**Consultation Response from KC,
Lead Local Flood Authority**

2024/92806 Land at, Penistone Road, Fenay Bridge, Huddersfield, HD8 0AW

Discharge of details reserved by conditions 20 (surface water discharge), 21 (flood routeing) and 31 (grass-crete and batter maintenance) of previous permission 2022/93154 for erection of 68 dwellings with associated access, parking, open space, landscaping and infrastructure works (including installation of surface water attenuation tank)

Date Responded: 17th April 2025

TITLE
DETAILS OF ATTENUATION/STORAGE
TANK DETAILS USING POLYSTORM
PSM1A UNIT.

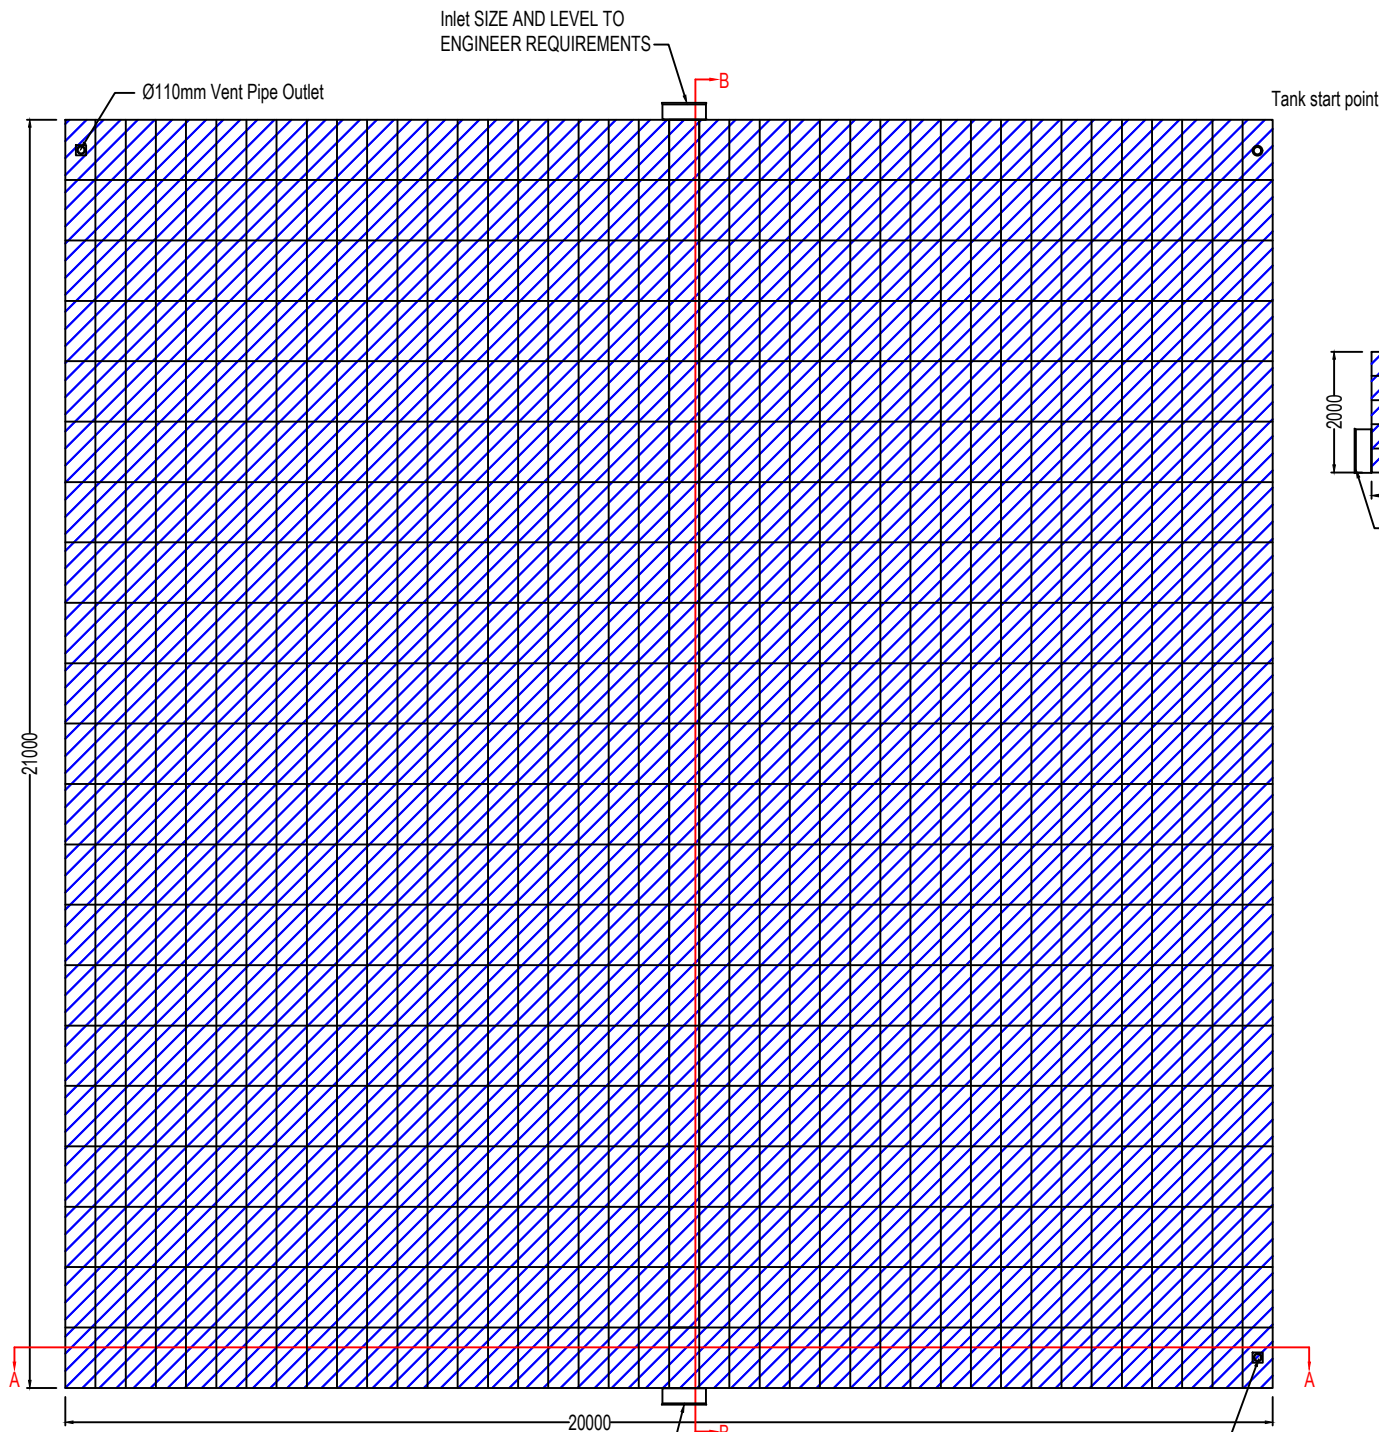
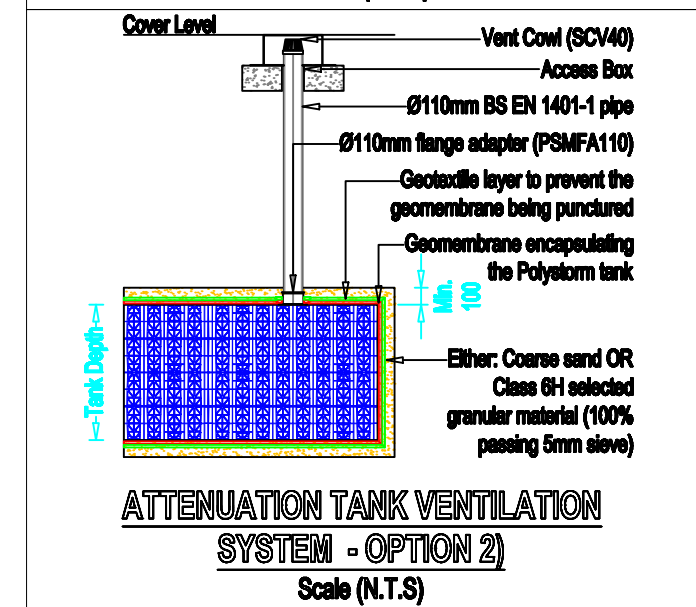
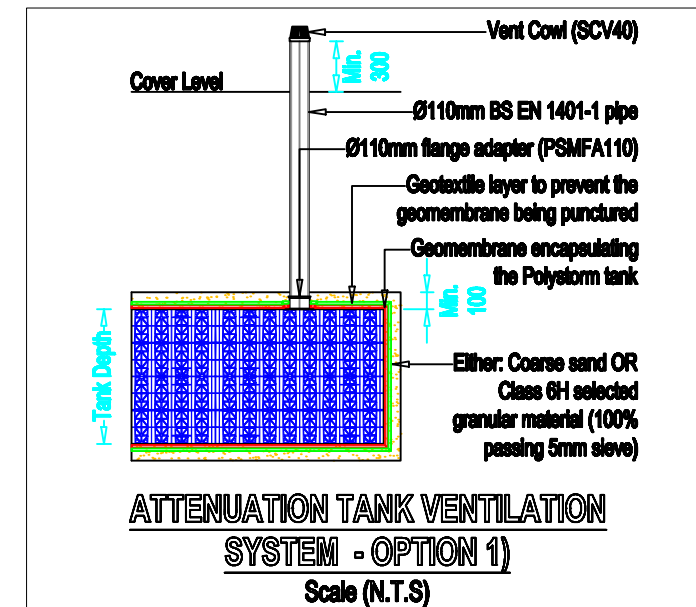
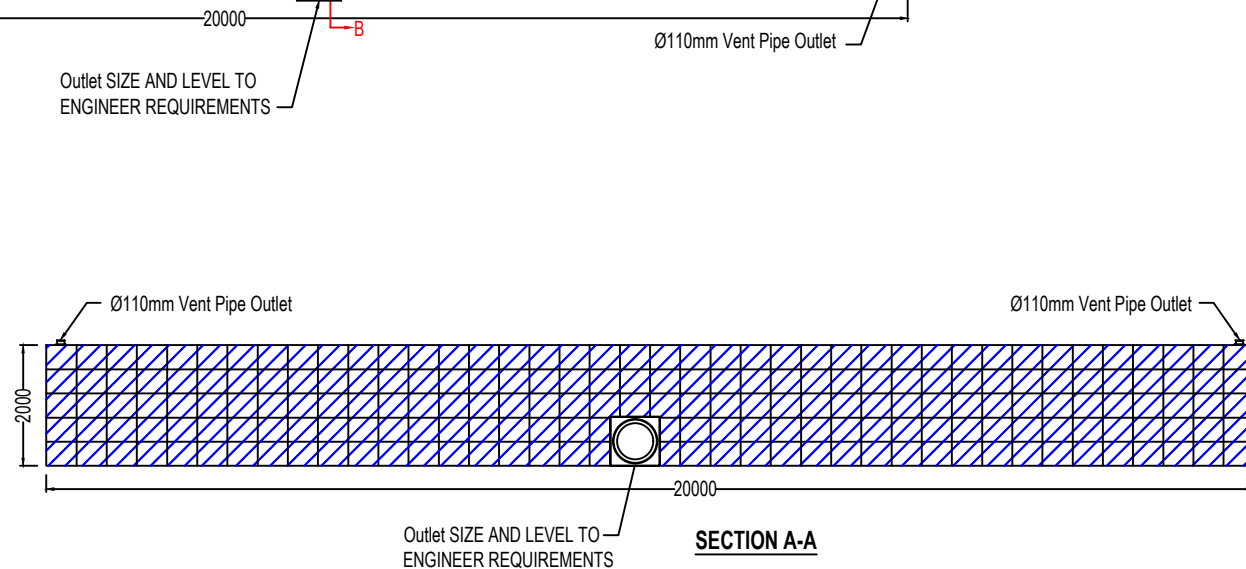
A 104 Technical Approval letter from a NAV has been included following our question of connection and outlet levels to the Polystorm R Tank.

It is noted that the Polystorm R tank should be at a minimum depth of 0.5m

Title: Outfall Headwall Details
Headwall1 HW1

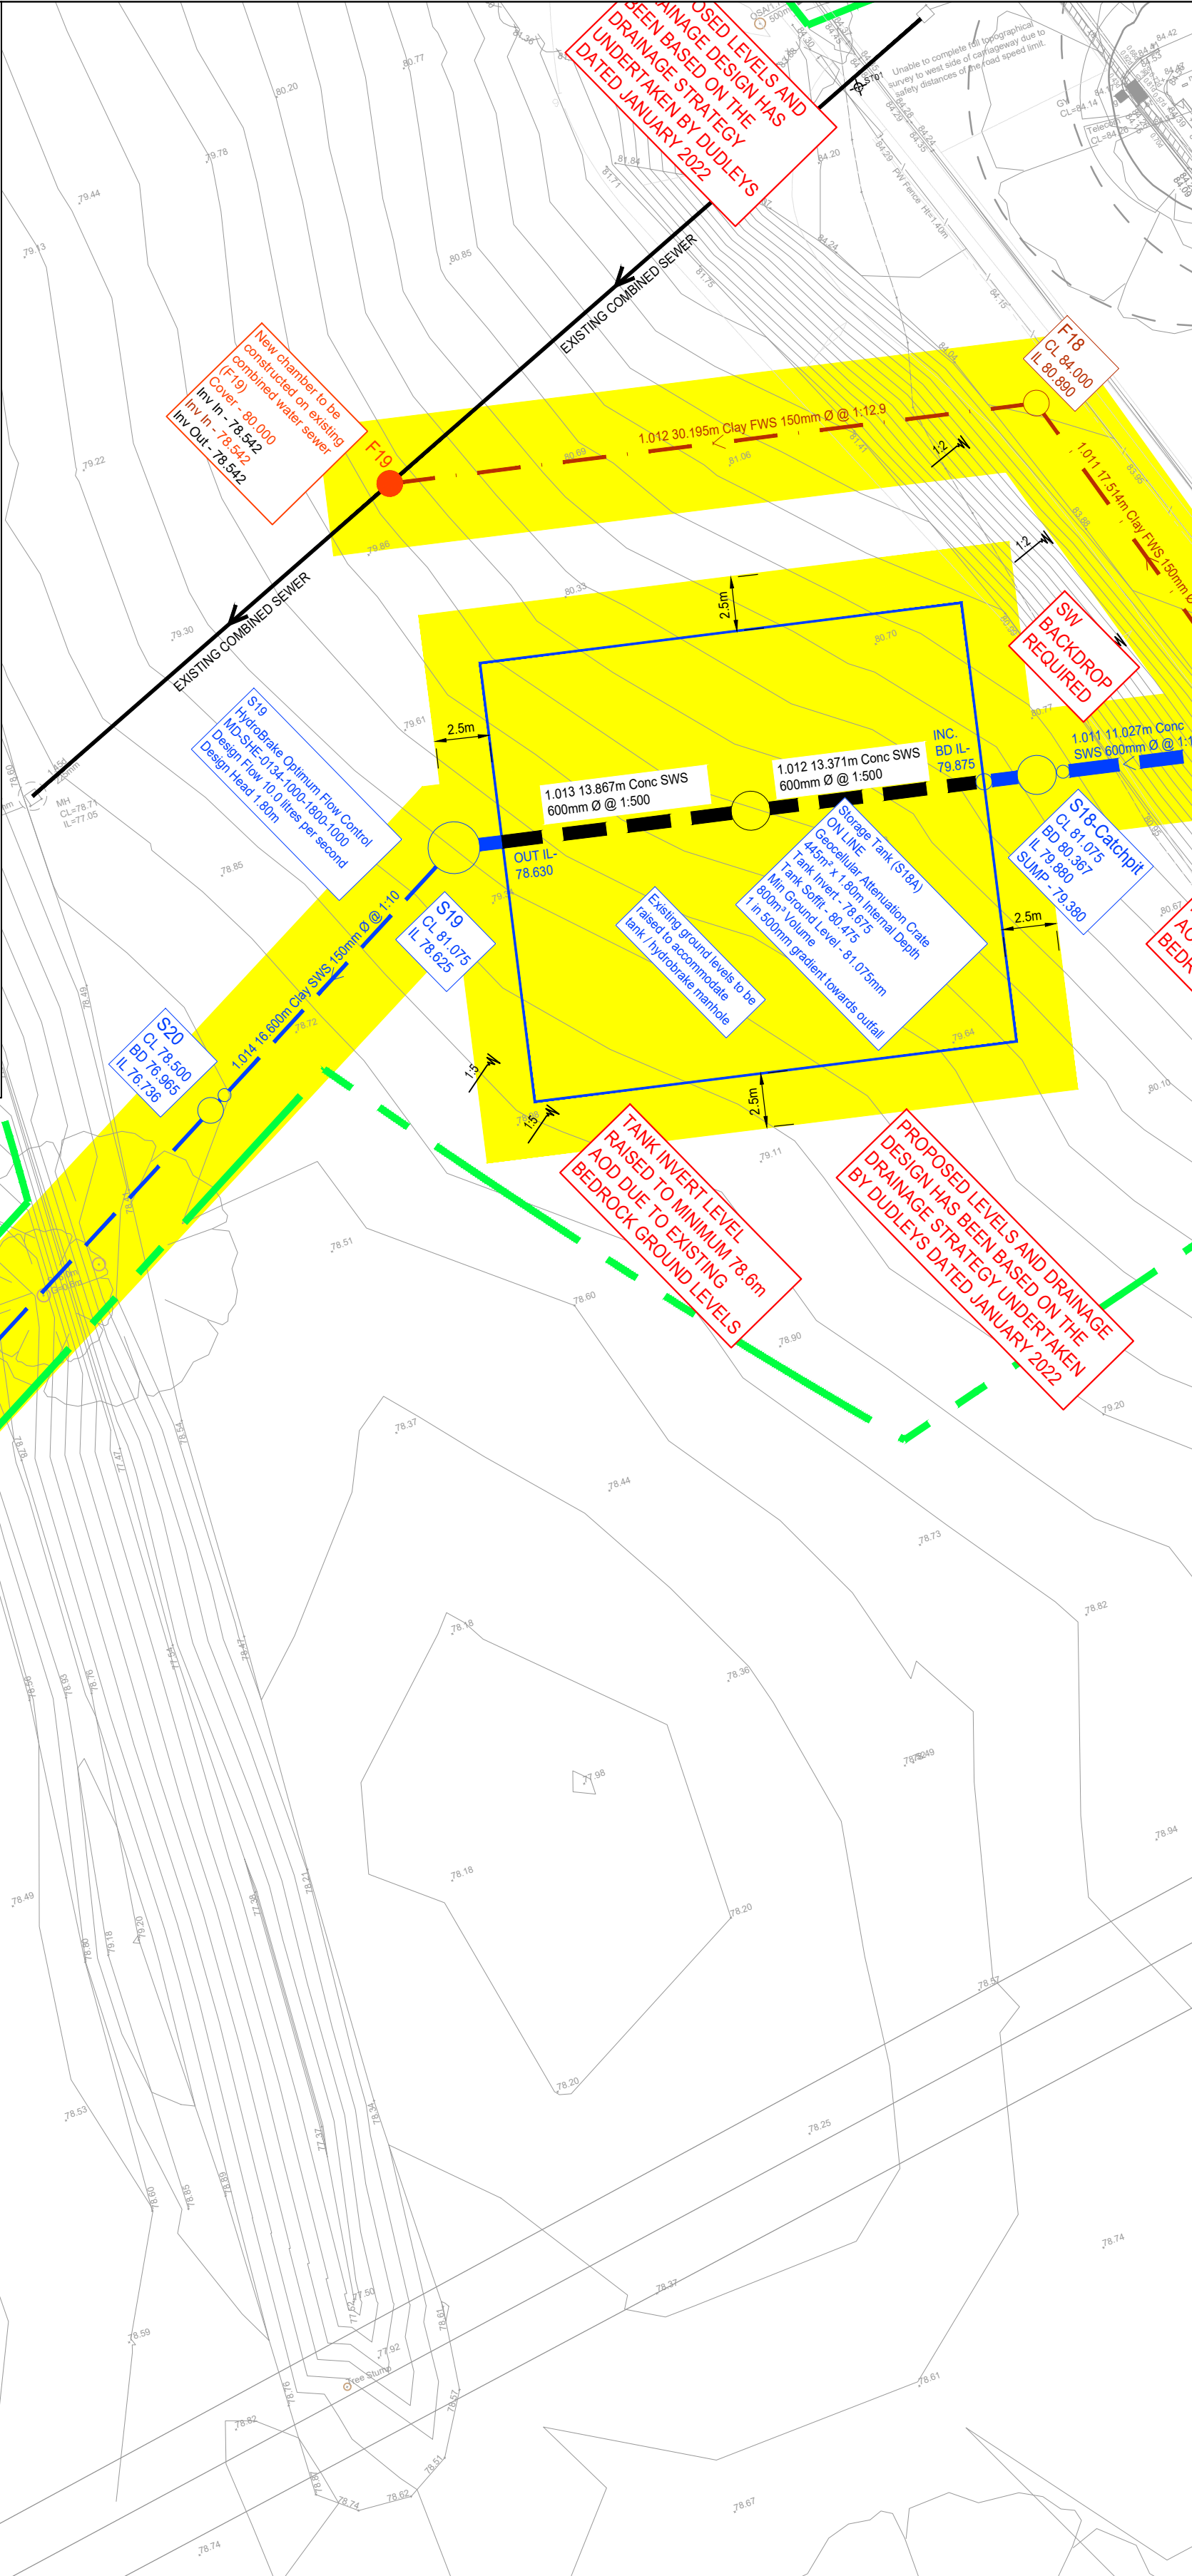
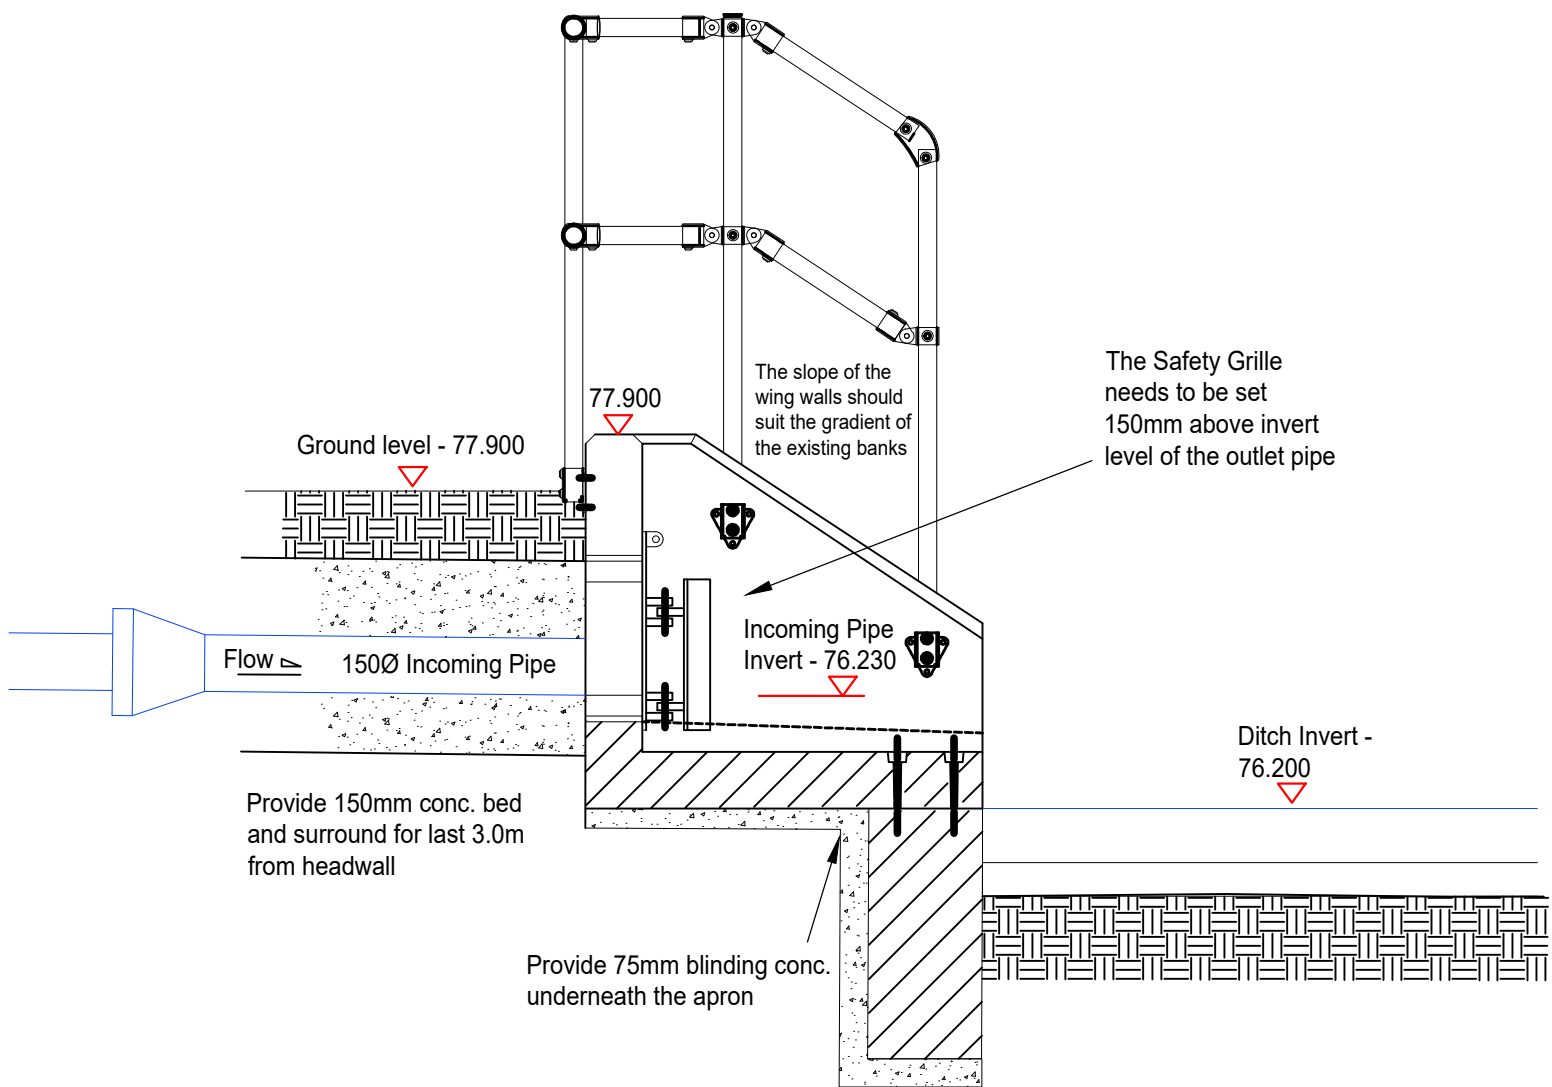
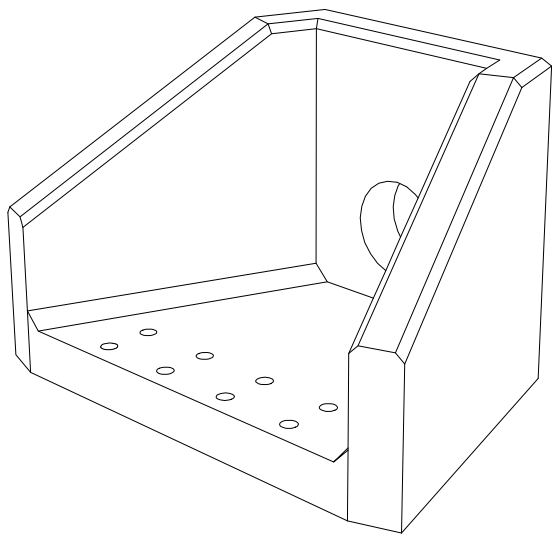
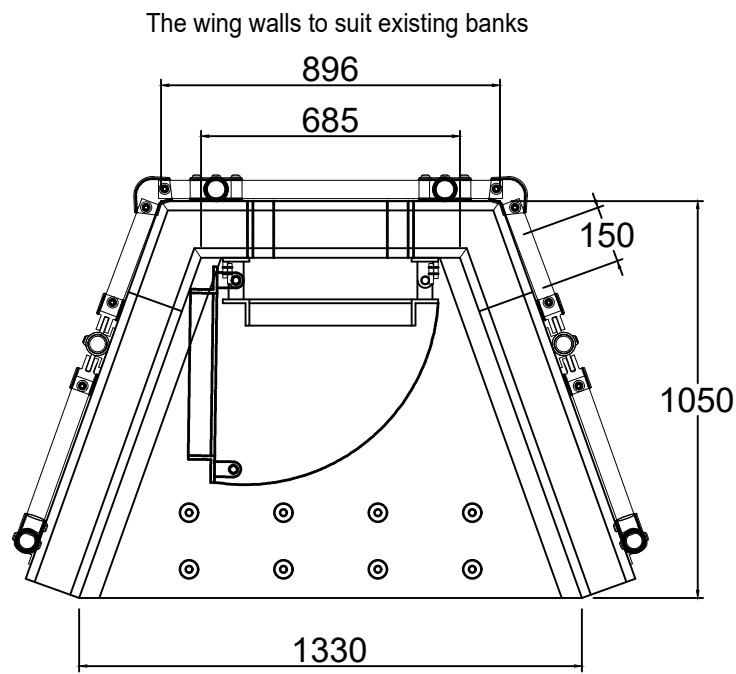
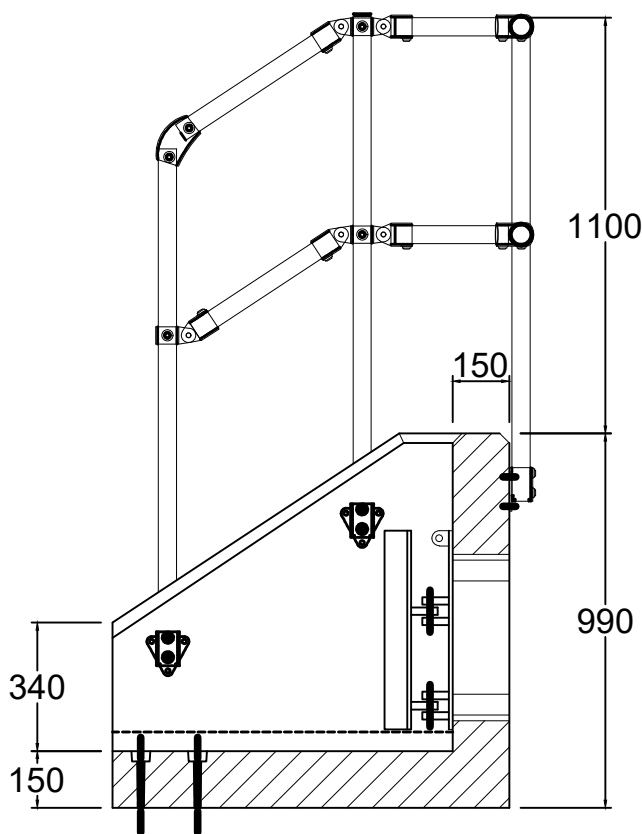
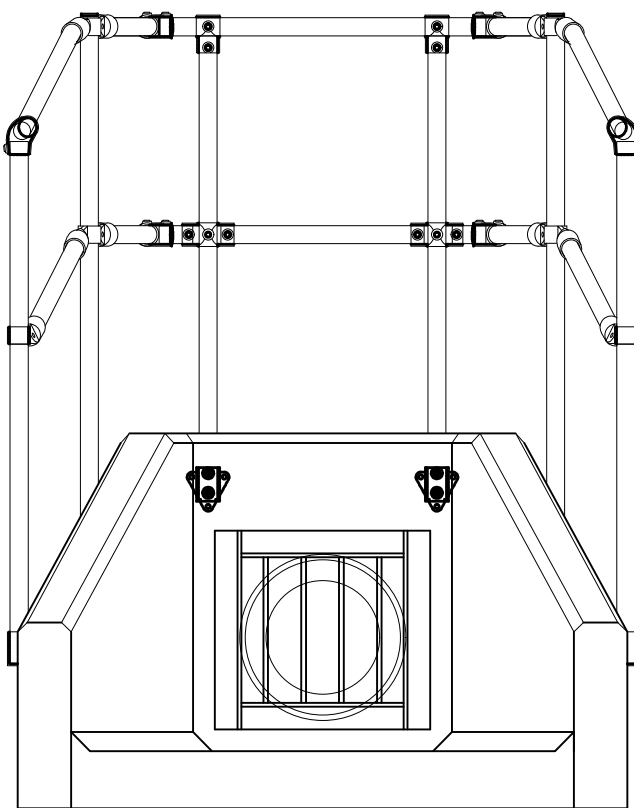
A revised headwall drawing has not been submitted.
